CITY OF ALBUQUERQUE

August 9, 2018

RE: UNM North 4th St Clinic
3401 4th St NW
Grading Plan Stamp Date: 6/25/18
Hydrology File: G14D086

Based on the submittal received on 8/6/18, this project cannot be approved for SO-19 Permit until the following are corrected:

DESIGNED BY	G.M.	DATE	8/18	BY	J.D.S.	REVISIONS	EXTEND HEADER CURB	JOB NO.	2018.170.2
DRAWN BY	S.C.C.	DATE						DATE	06-2018
APPROVED BY	G.M.	SHEET	1	OF	4

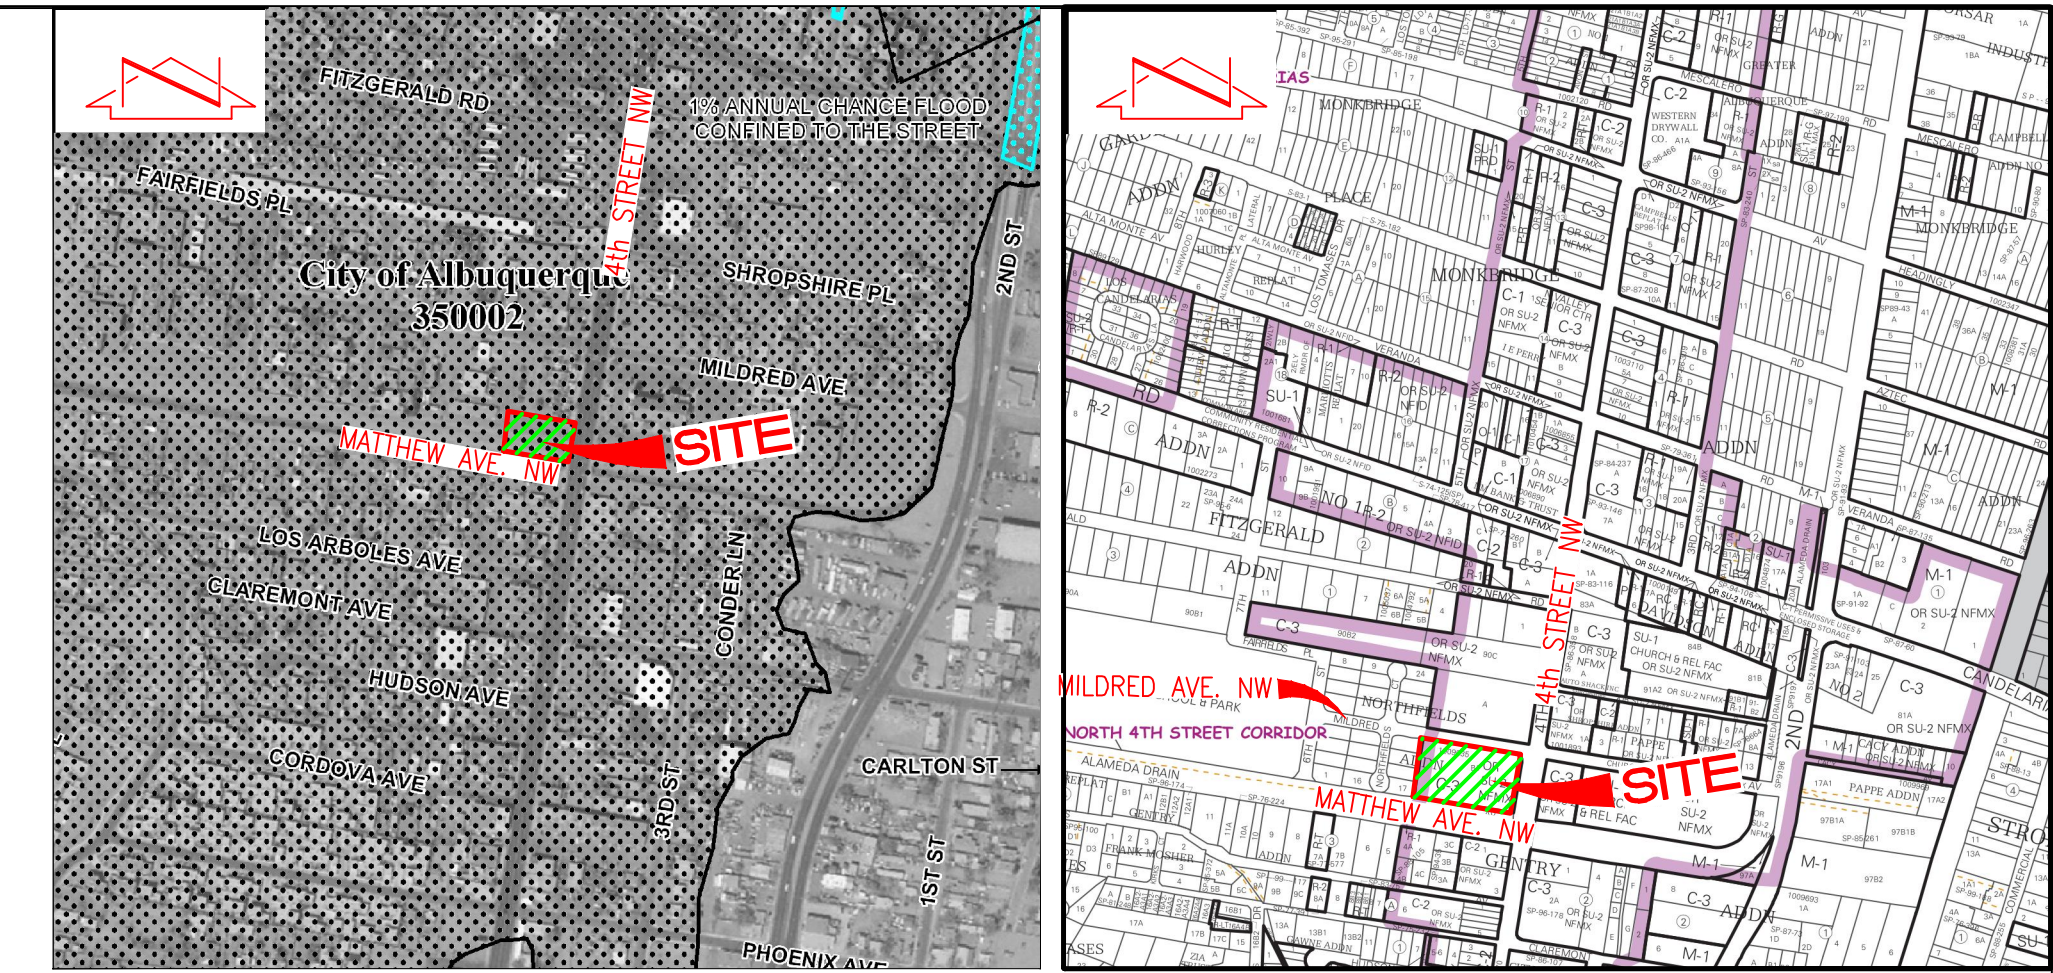
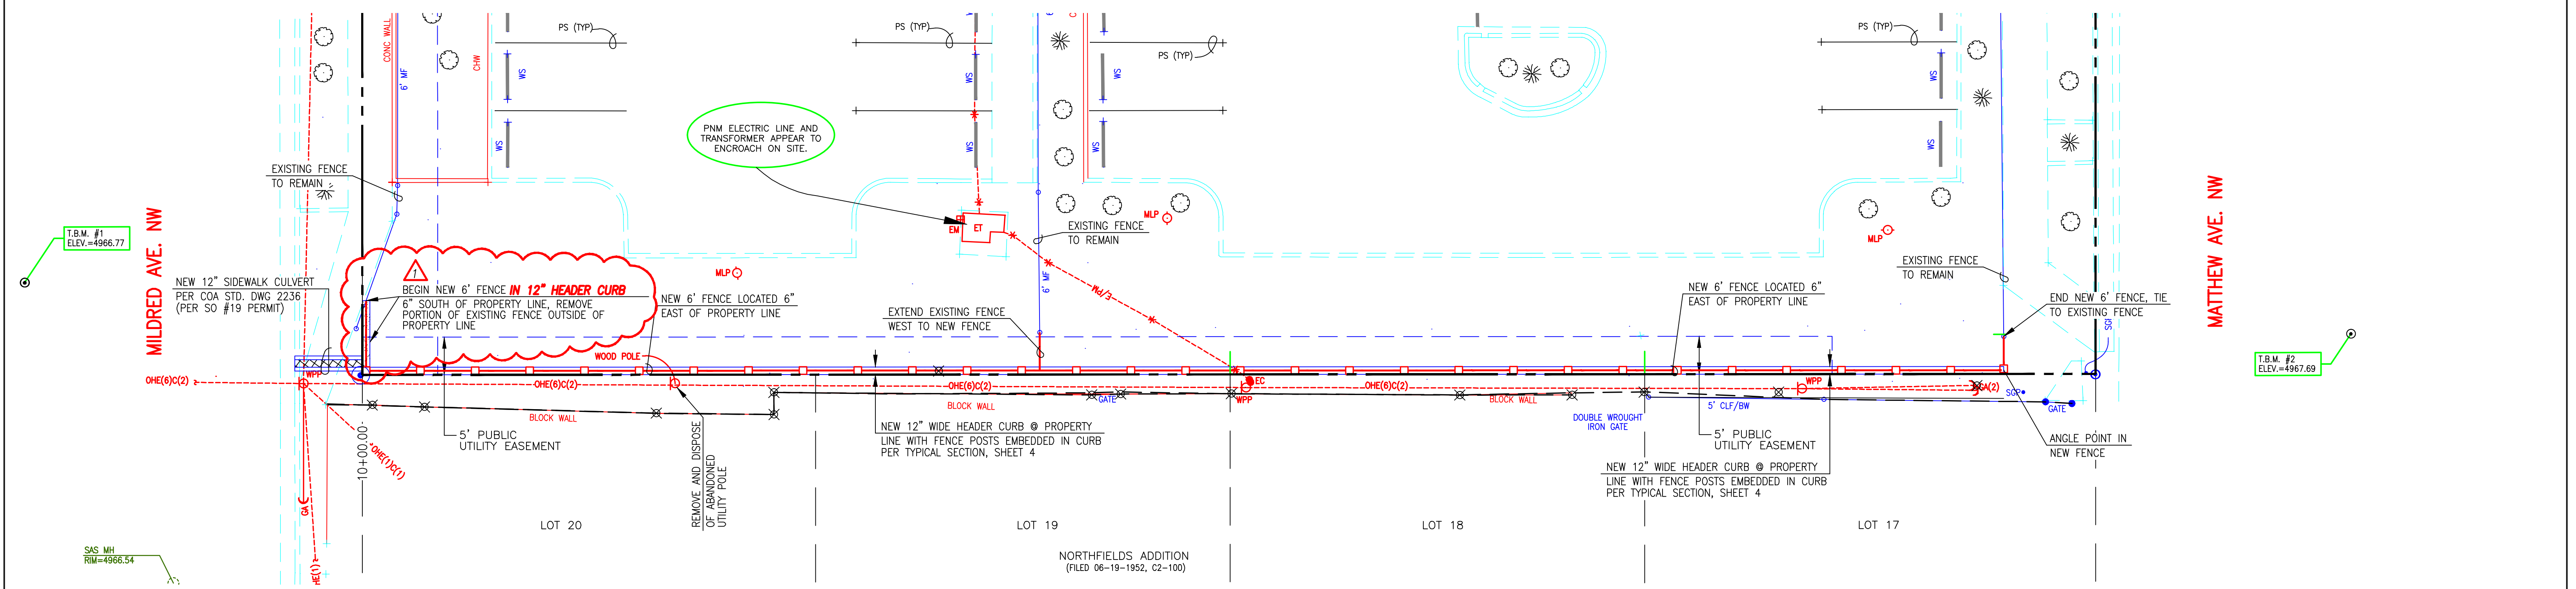
1. Provide a detail for the 6" drain pipe into the back of the sidewalk culvert. It appears a small concrete headwall around the 6" pipe will be needed to keep dirt from flushing into the culvert and to support the abrupt transition in the finished grade at the ROW line.
2. Include the [standard SO-19](#) notes on the grading plan.
3. Use the [current DTIS version](#) (6/2018) when resubmitting.
